Planning Consultation Memo

Date	Planning Officer	Environmental Health Officer
26/06/19	A Commenville	Karl Riahi
Planning Application Number	Worksheet Number	
6/2019/1247/FULL	WK/108798

Address: Eisai Europe Limited European Knowledge Centre Mosquito Way Hatfield AL10 9SN

Application Details: Installation of chillers on the roof of the existing building

Drawing Title:  
**PRODUCTION BUILDING  
 ROOF PLAN OF PROPOSED  
 CHILLER INSTALLATION SCALE 1:100**

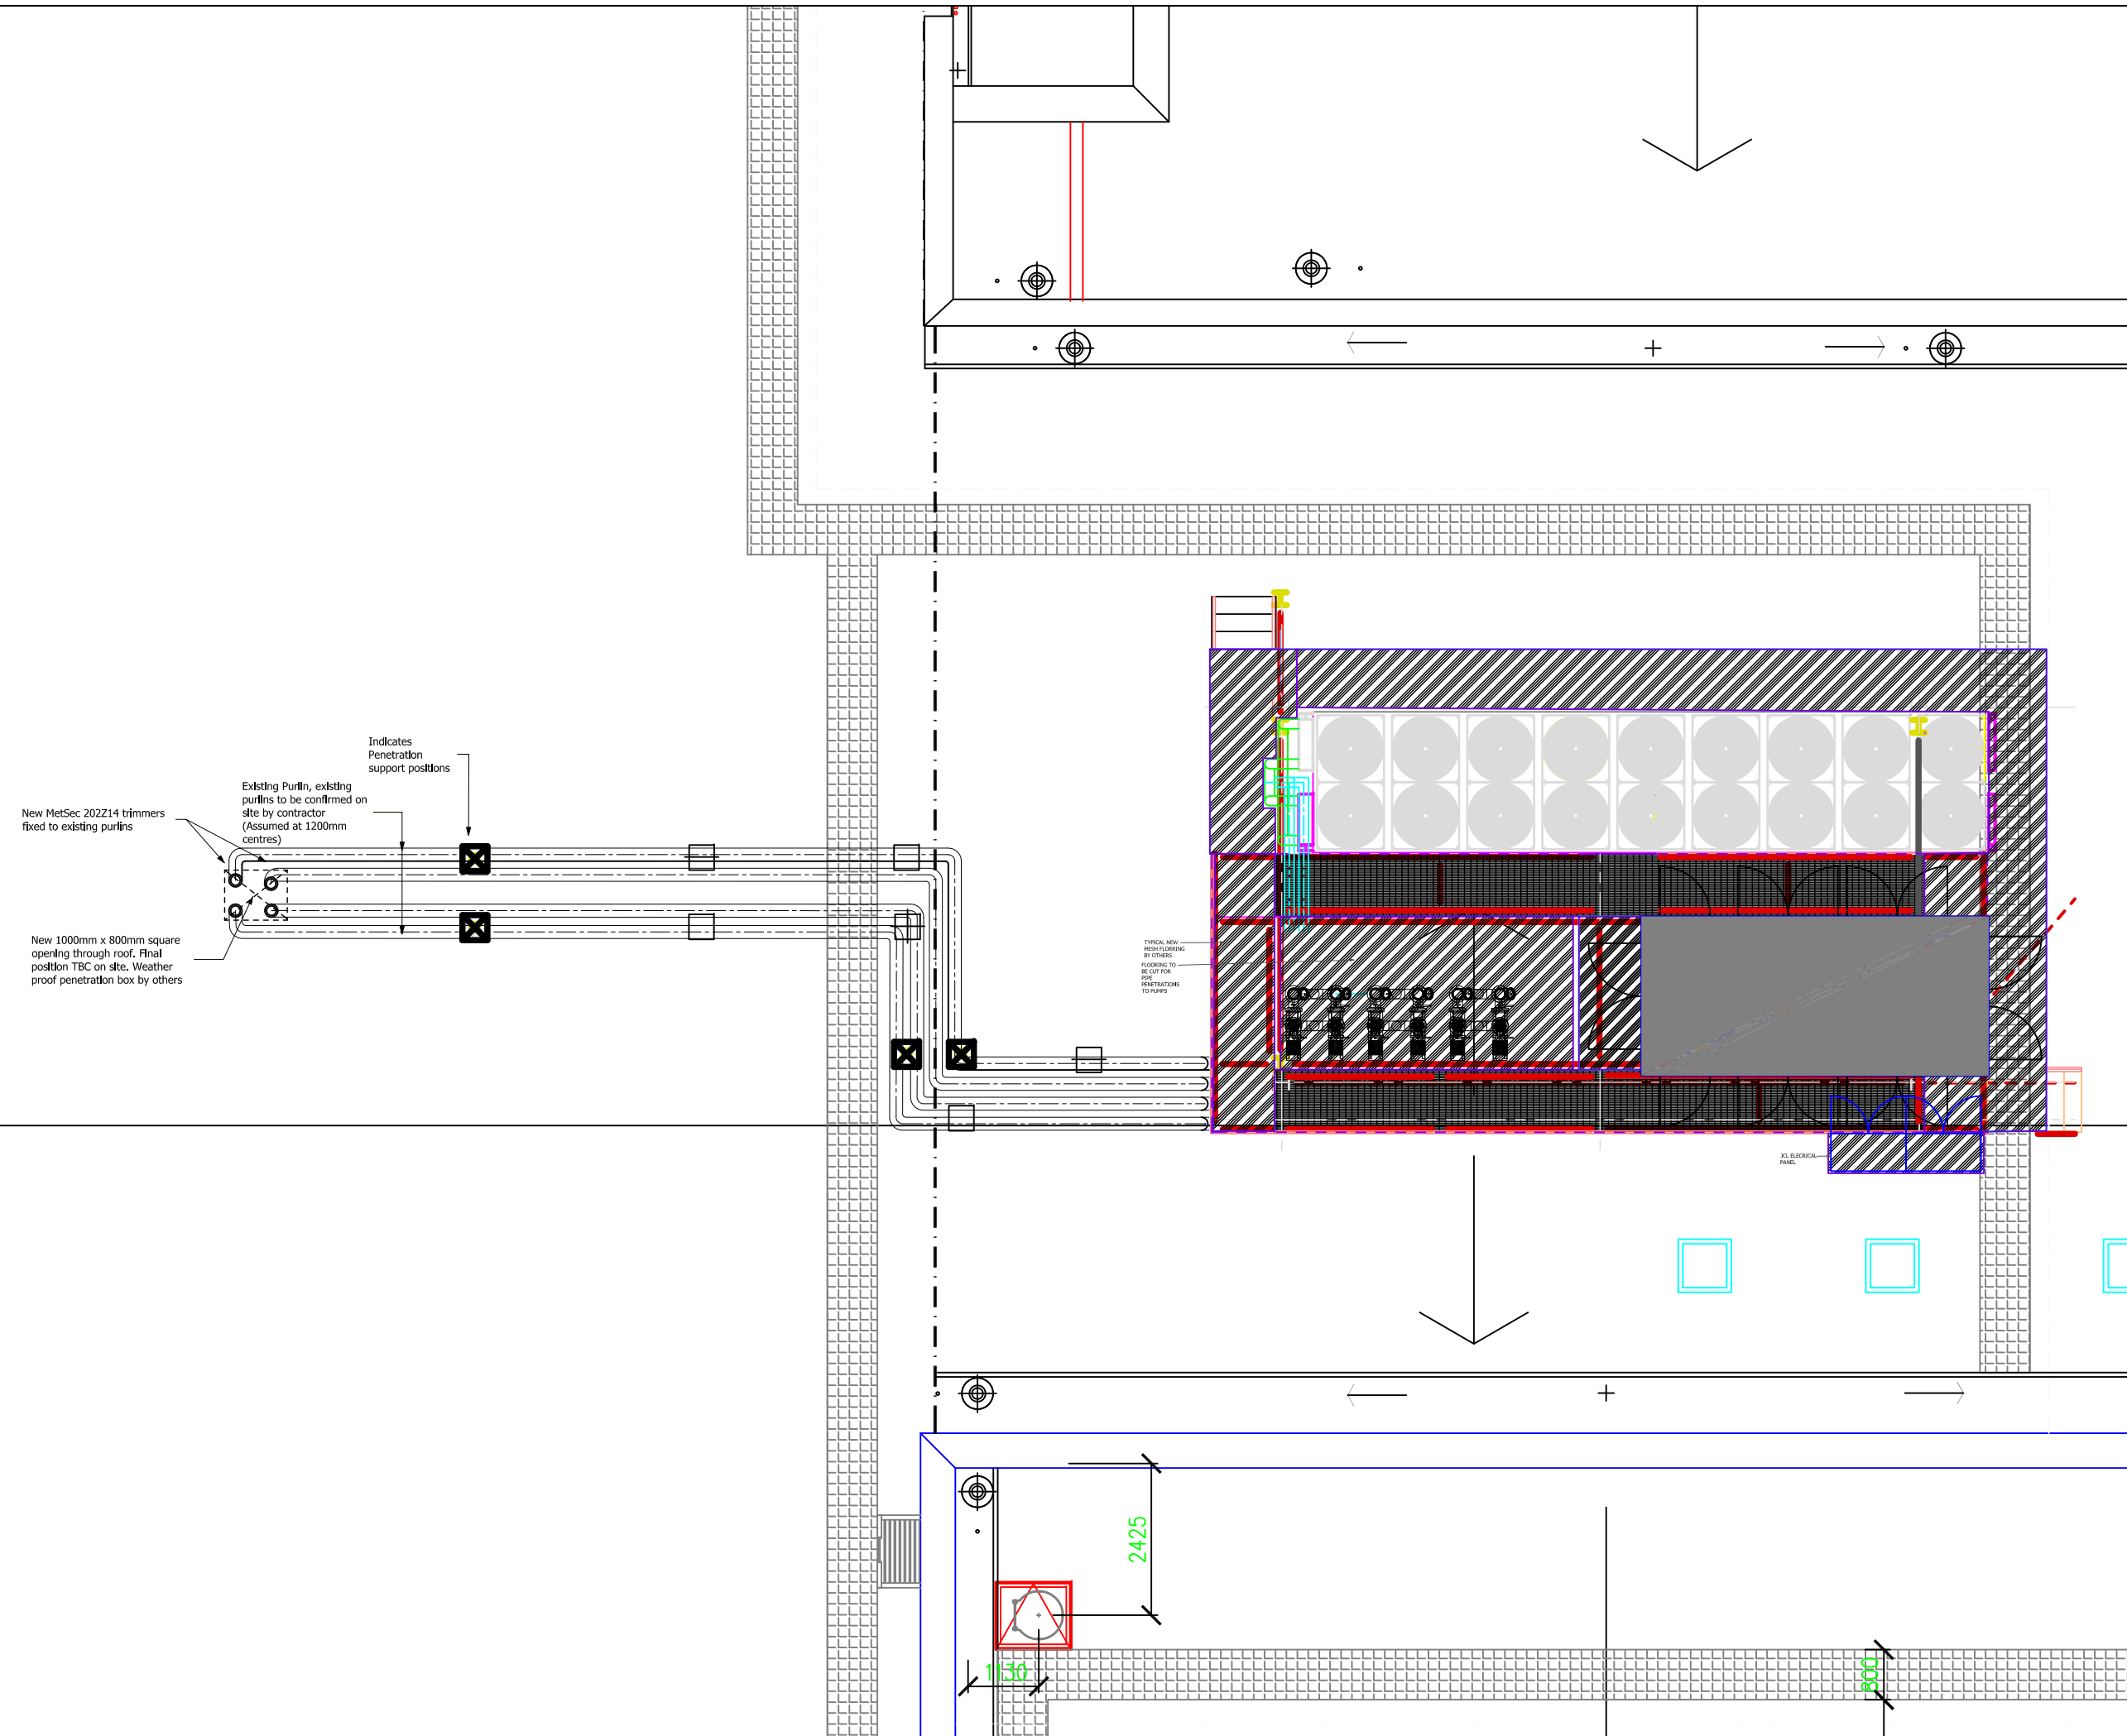
Information provided by the applicant shows that the external noise levels associated with the proposed chillers are 67.3dB at 10m which will be located approximately 115m from the nearest residential properties, there is also a high wall located where the chiller is to be installed which will provide additional shielding.

Distance attenuation calculations show that without taking into account shielding from the wall, the noise level at the nearest residential properties will be in the region of 46dB. Without knowing tonality, the level of shielding expected or the background noise levels in the area, it is thought that there is still the potential for a detrimental impact on amenity.

It is recommended that the standard plant and equipment condition is placed on the application, so that there can be confidence that this proposed development will not detrimentally impact on the nearest residential properties, and where required, additional mitigation measures can be incorporated into the installation at the outset.

Noise from plant and equipment associated with the development shall be 10dB (LAeq) below the background noise level (LA90) at the nearest residential properties (5dB below the background noise level if evidence is provided which shows that no tonality is present).
